PLANNING APPLICATION 21/ 00922/ OUT
9 DWELLING AT LAND WEST OF FOXDENWAY GREAT BOURTON

We would wish to object to the above revised application for the same reasons as our original objection of April 14th 2021, a copy of which, for the avoidance of doubt is attached.

TITLE
PROPOSED SITE ACCESS JUNCTION WITH VISIBILITY SPLAYS

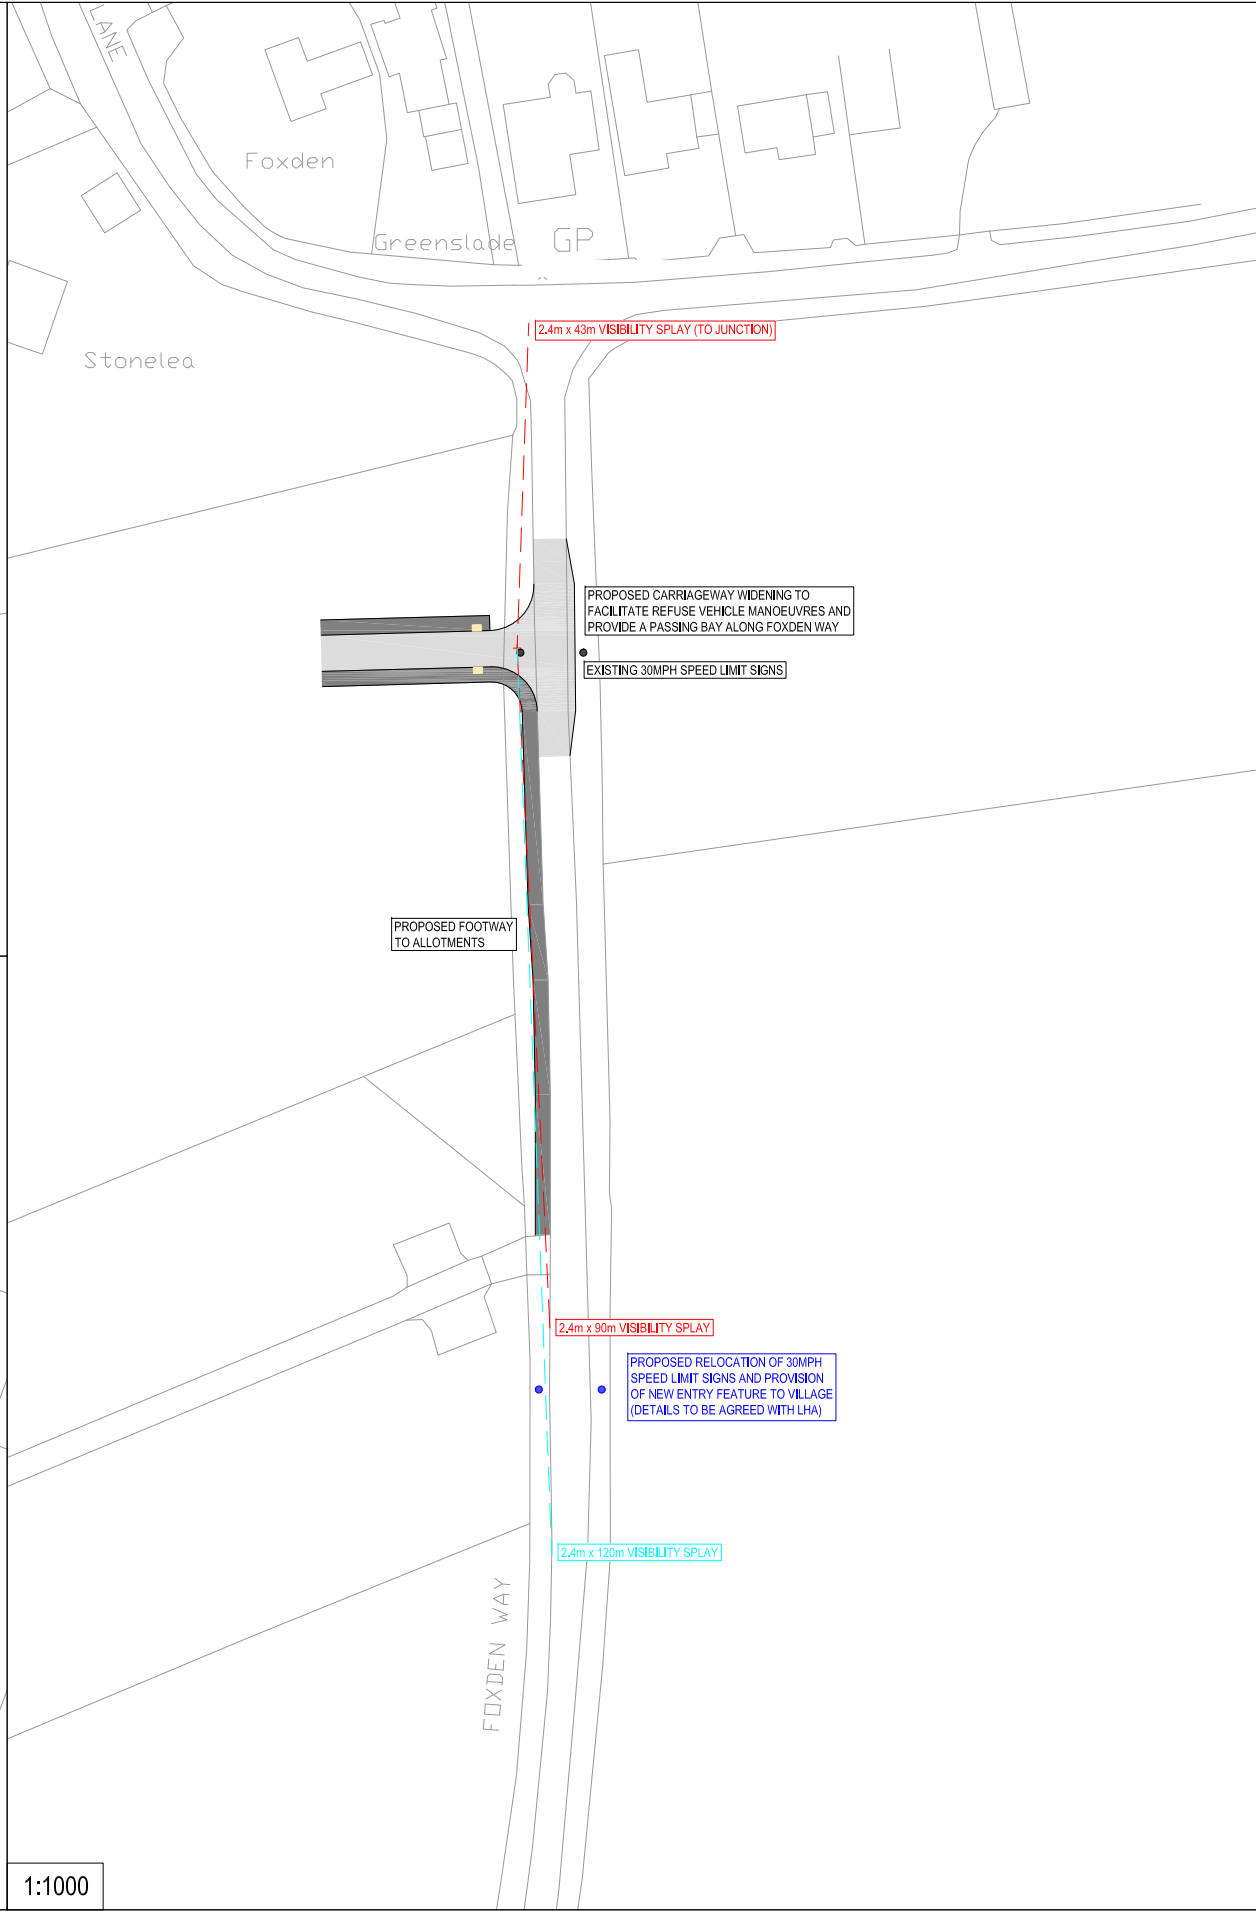
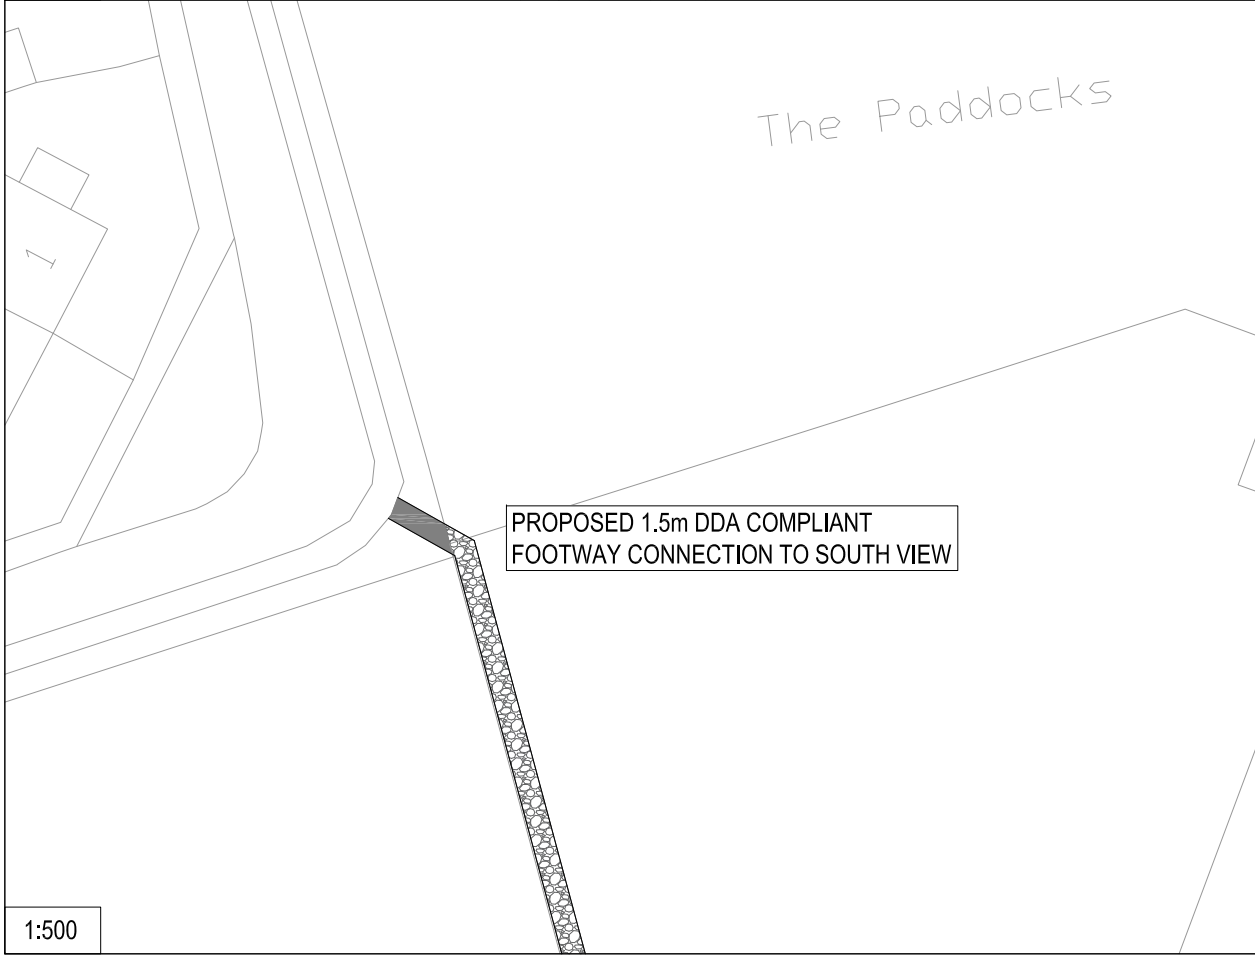
We would also wish to object to the revised site access arrangements including the proposed footpath which would appear to urbanise what is at present a single track country lane, and would no doubt encourage motorists to increase their speed when leaving the village to the detriment of any villagers walking on the road beyond the " safety " of the footpath
